Retention of 1.8m high trellis fence to front boundary.
2 Sea Lane Gardens Ferring

Thank you for your internet representation made on 2nd July 2018 which has been recorded as '**an objection**' with the comments as follows:

Elevation to Sea Lane

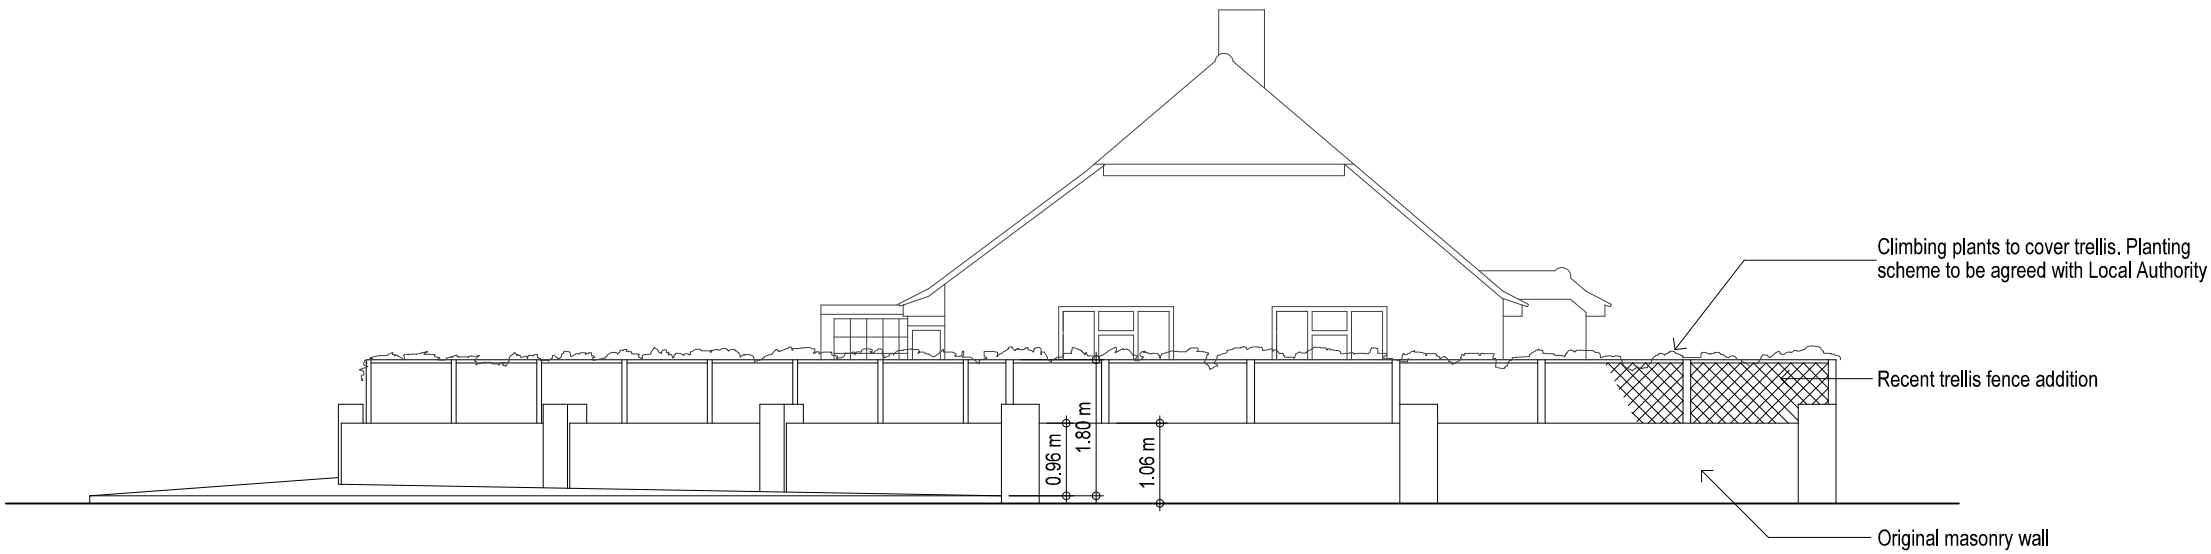
*The fence is too high and not permitted by planning regulations
It is also not sympathetic to the surrounding properties and is challenging for drivers
coming out of Sea Lane Gardens*
